Ribble Valley Borough Council
Housing & Development Control

Application no: **3/2019/0917**

Address: **1 Hollies Road Wilpshire BB1 9NA**

Proposal: **Proposed first floor extension to side**

Project Proposed extension 1 Hollies Road, Wilpshire, BB1 9NA	
Description site plans	Scale 1:200 @ A3
Client Mr. R. Cooke	Drawn CW
Date Sept 2019	Drawing No 493/03A

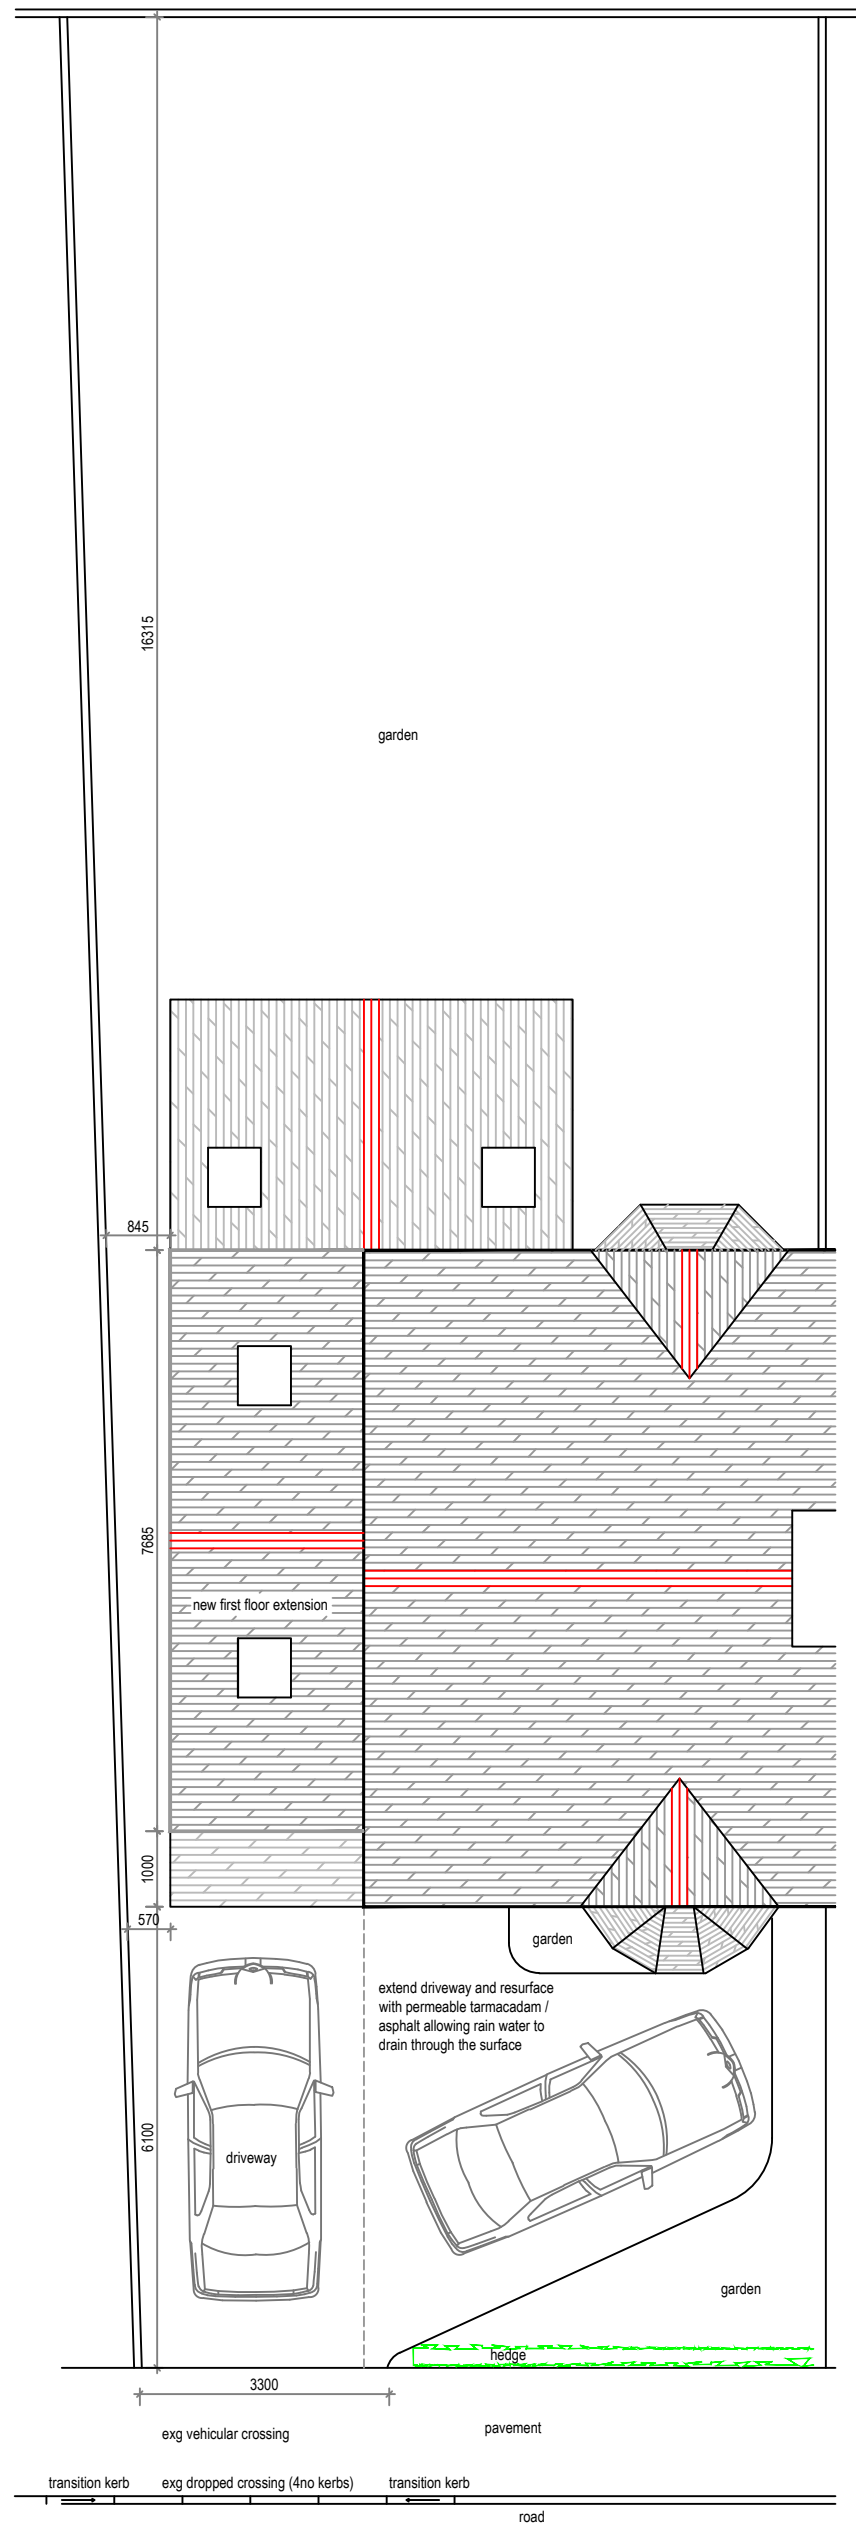
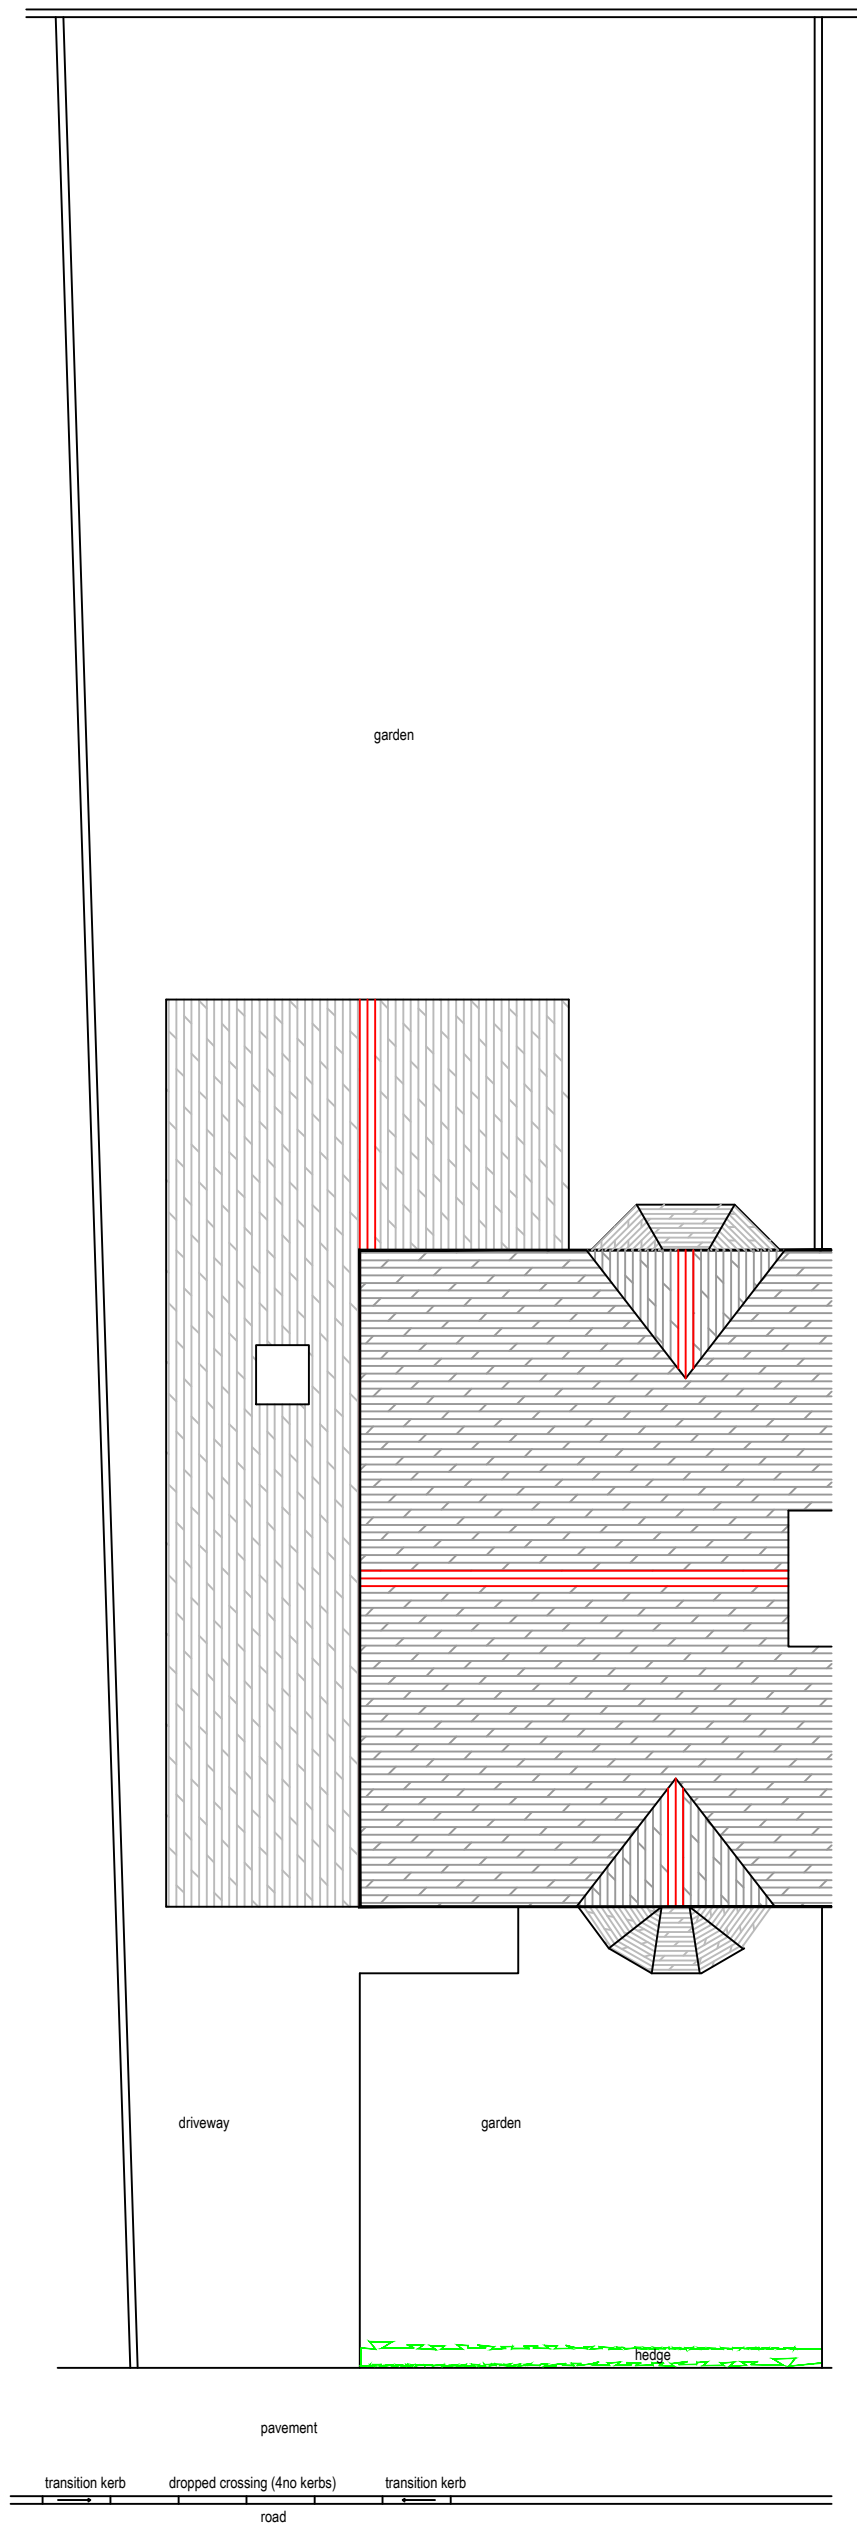
The existing parking provision will be retained at two parking spaces as a result of the proposal and whilst the driveway is proposed to be extended by 2.4m. In accordance with the submitted plans, this will provide an overall width of 5.3m. However, for the perpendicular parking of two vehicles whilst providing pedestrian access to and from the property the applicant will need to demonstrate a driveway width of 6m. The drive shall also be constructed with an approved bound porous surface material.

Project Proposed extension 1 Hollies Road, Wilpshire, BB1 9NA	
Description site plans	Scale 1:200 @ A3
Client Mr. R. Cooke	Drawn CW
Date Sept 2019	Drawing No 493/03

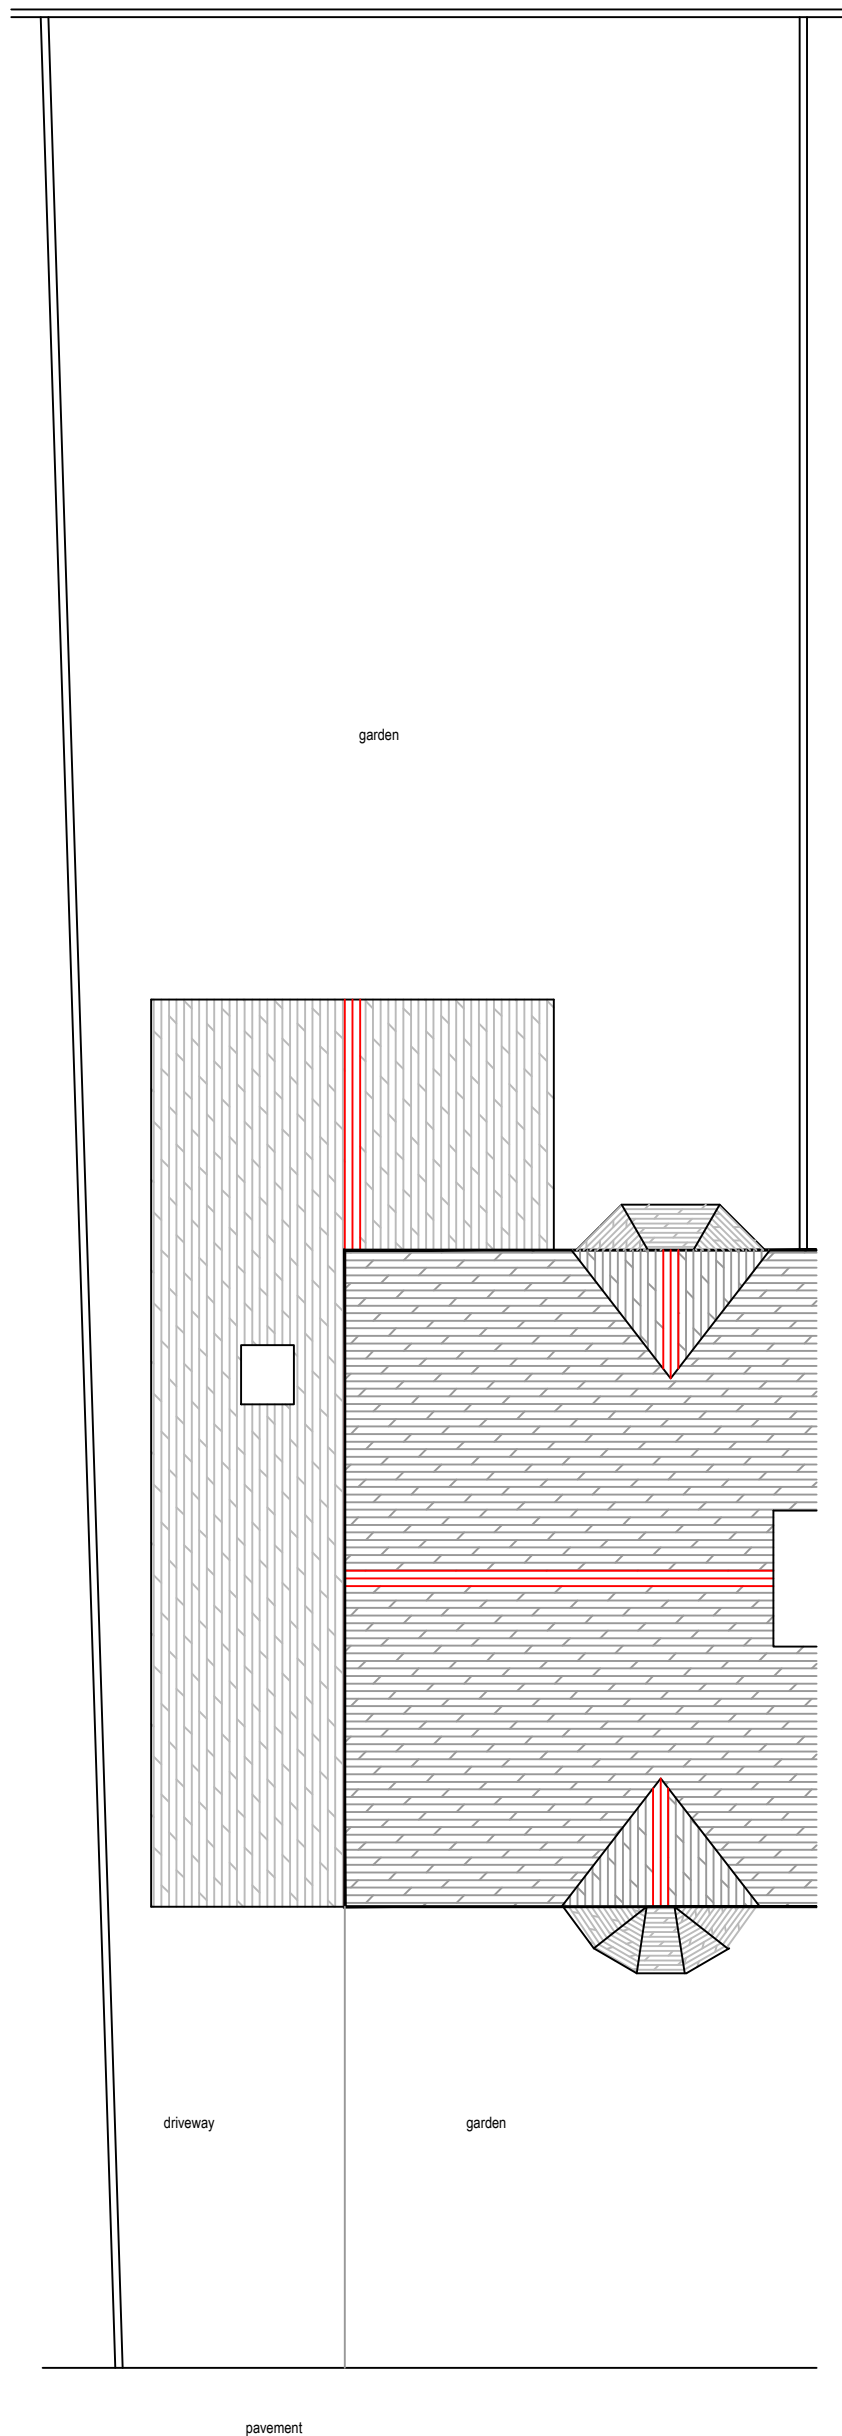
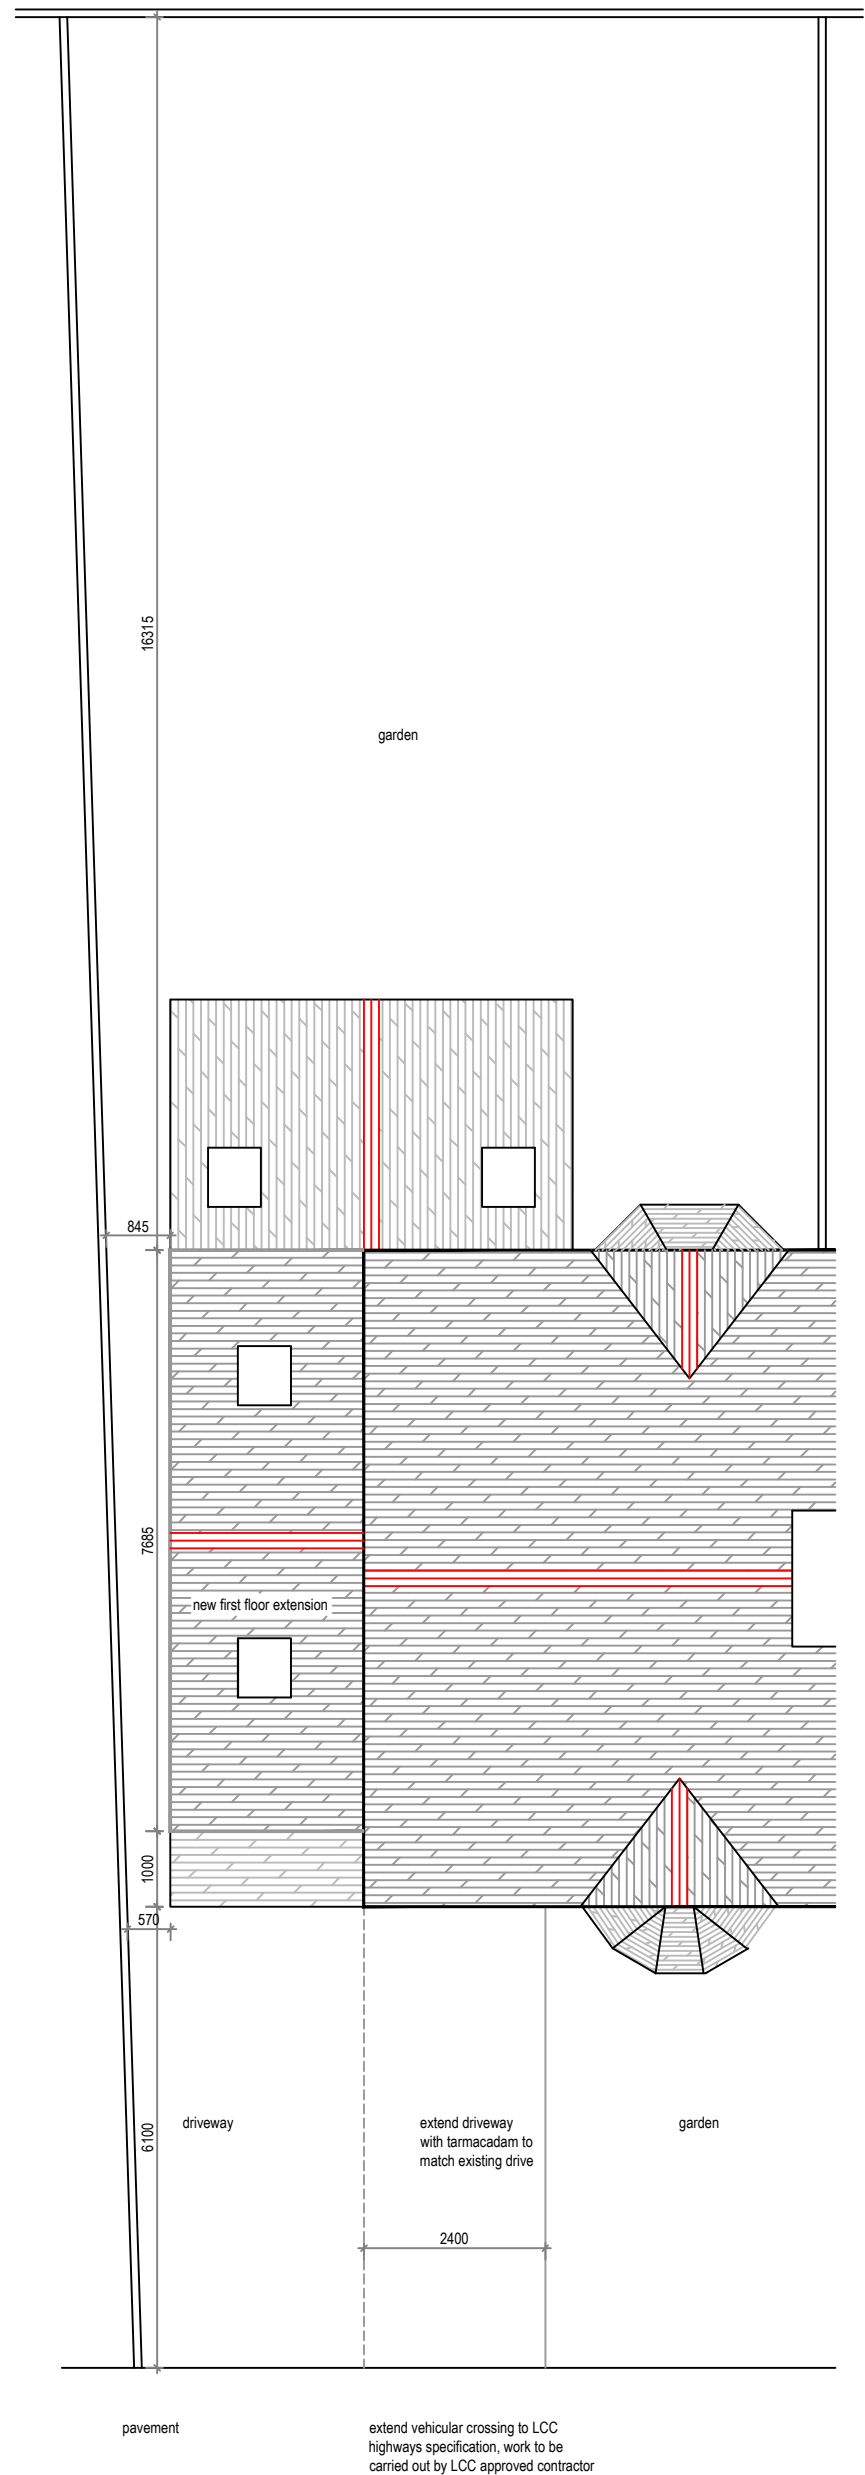
The extension of the existing vehicular dropped crossing fronting the dwelling shall be carried out under section 184 of the highways act 1980.

The Local Highway Authority would require the plans be revised.
